CITY OF ALBUQUERQUE

November 6, 2012

**Re: Red Rock Roasters, 4801 Jefferson NE,
Traffic Circulation Layout
Architect's Stamp dated 10-26-12 (F17-D096)**

F-17/DO96

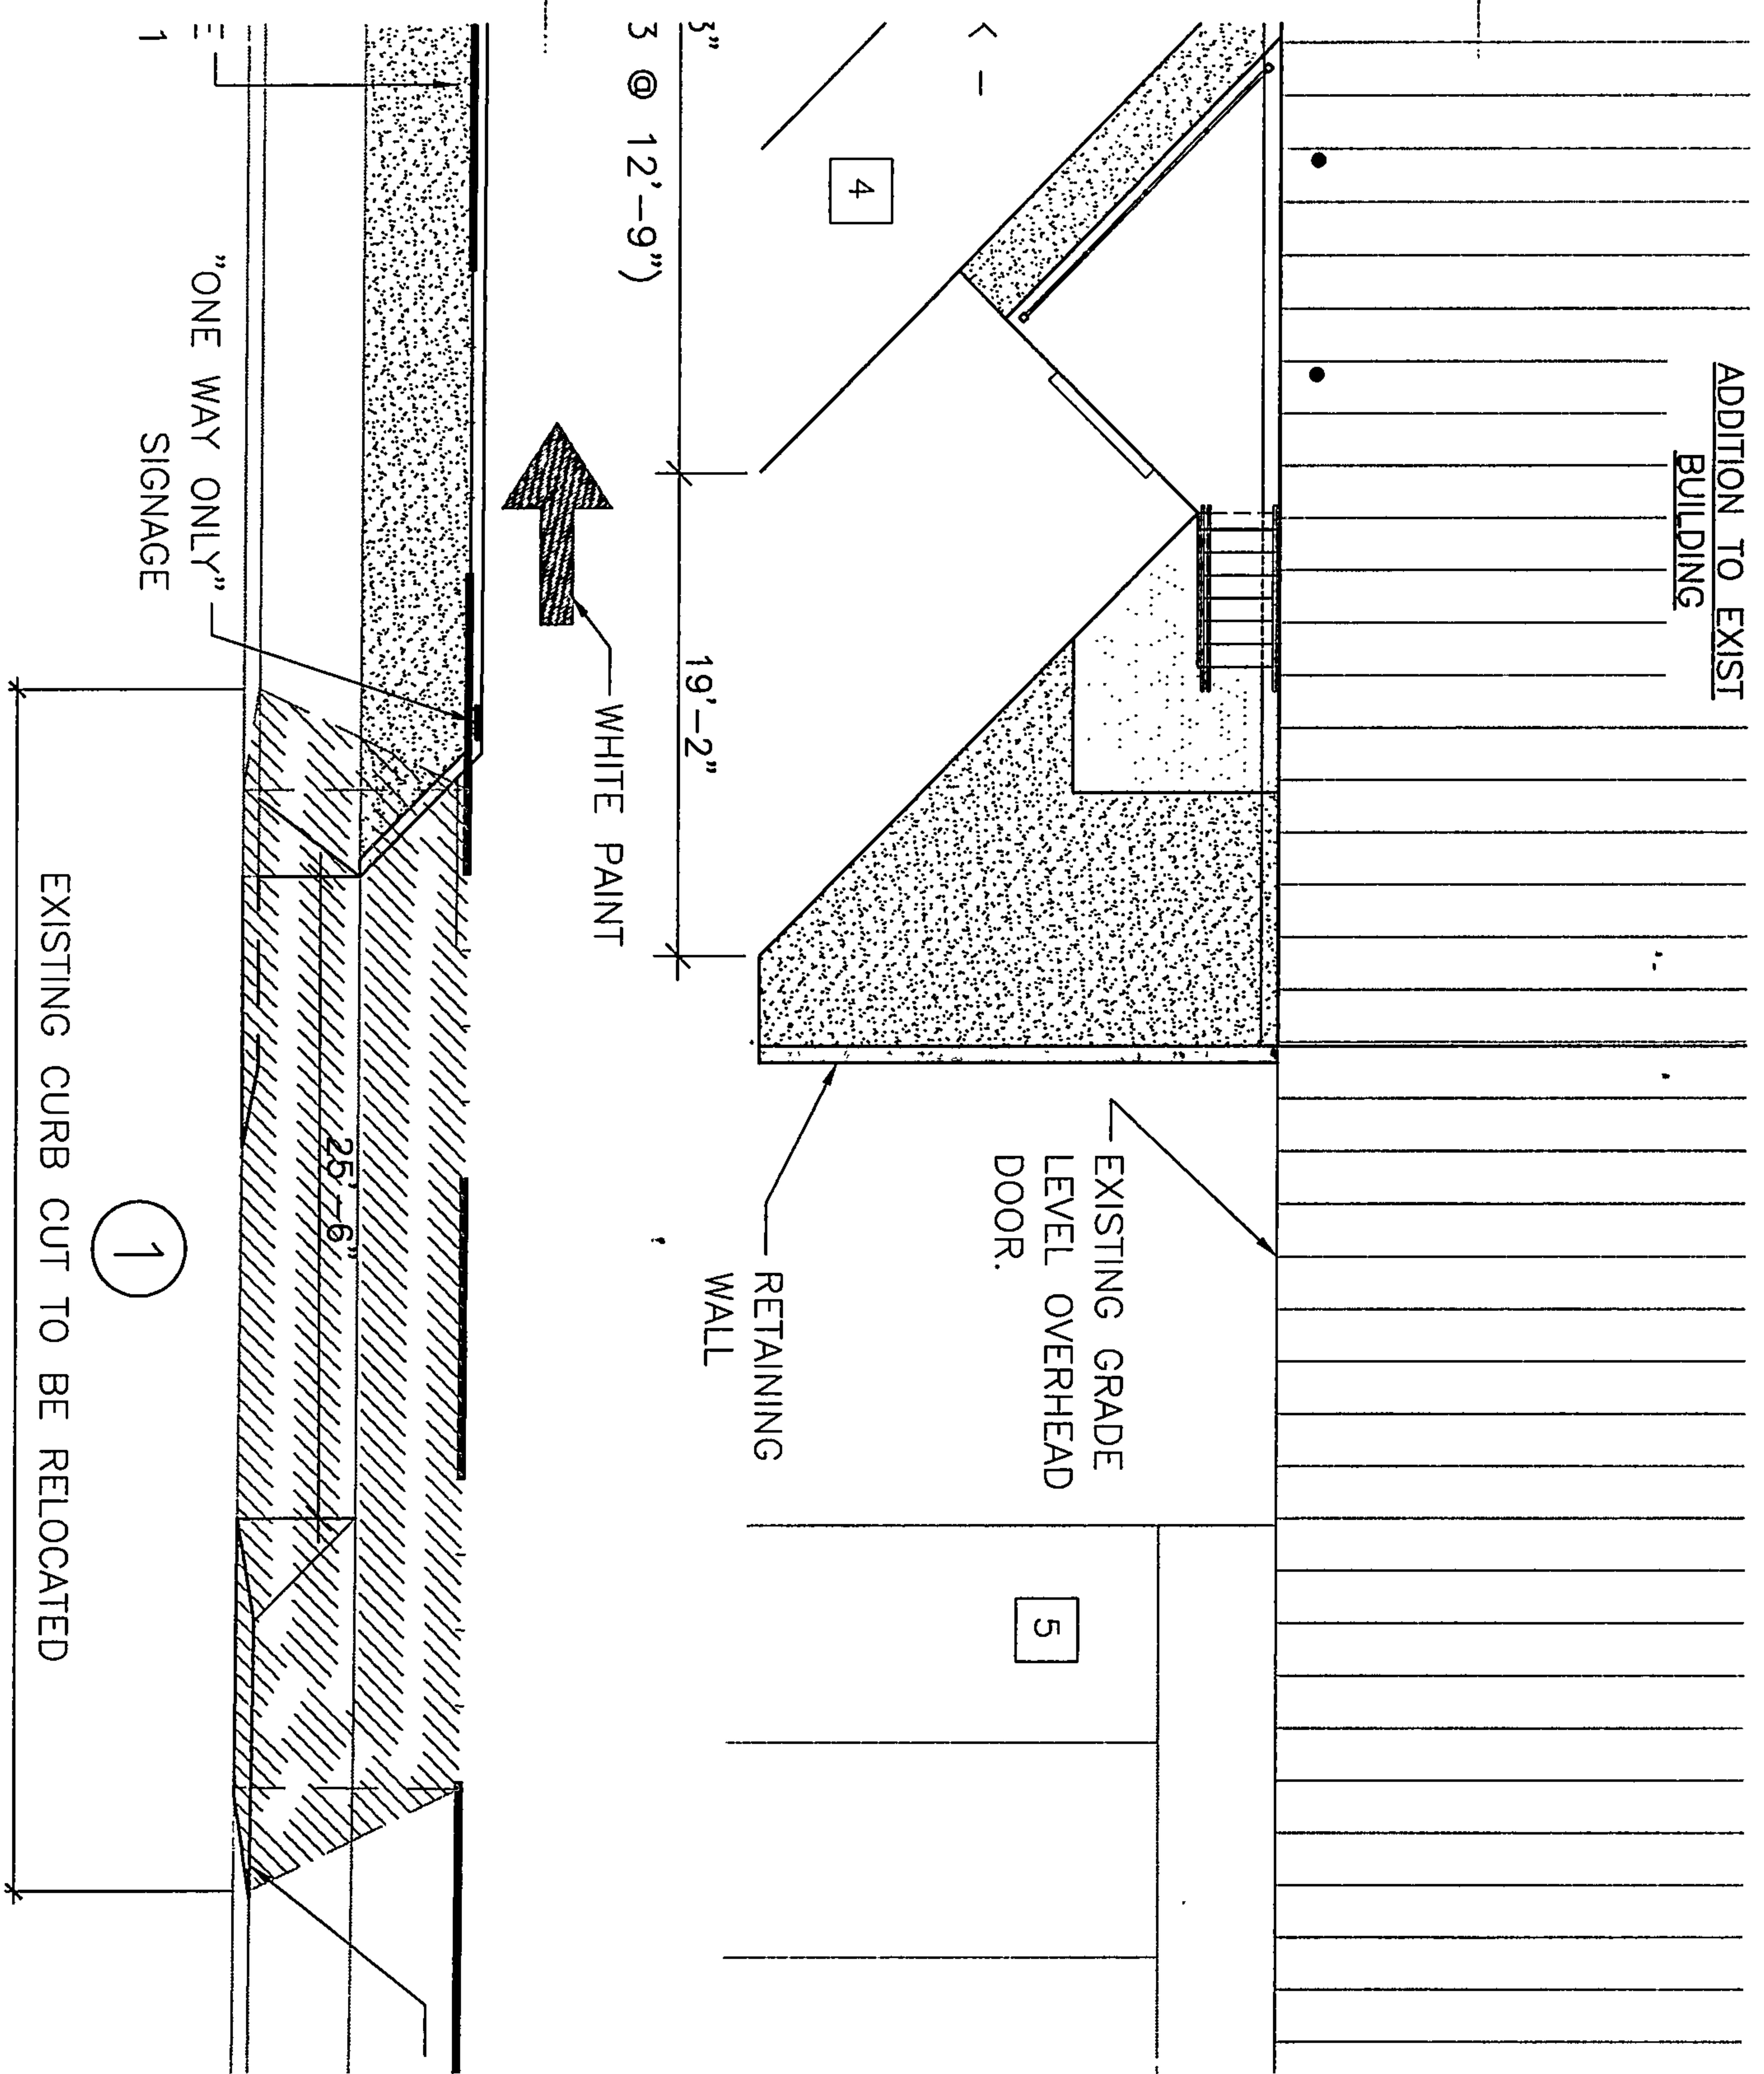
7. Please provide a legend and/or keyed notes detailing line types, hatching, proposed and existing conditions for clarity.
8. The proposed location of the refuse interferes with the 45 degree angled parking stall when the refuse doors are swung open. Please revise.

9. Please indicate the required 6 foot ADA accessible pedestrian pathway from COA ROW to the building.
10. Please provide directional signage / striping to indicate one-way movement through parking area and at the existing southwest curb cut indicating egress only, all signage within property line. (Recommend adequate "One-Way Only" signage in parking area and 2 each "Do Not Enter" signs posted at both sides of turn-out.)

11. Please provide dimensional details of the proposed perimeter fence and gates.
12. What is the width between the proposed fence and the building? Is pedestrian access needed?
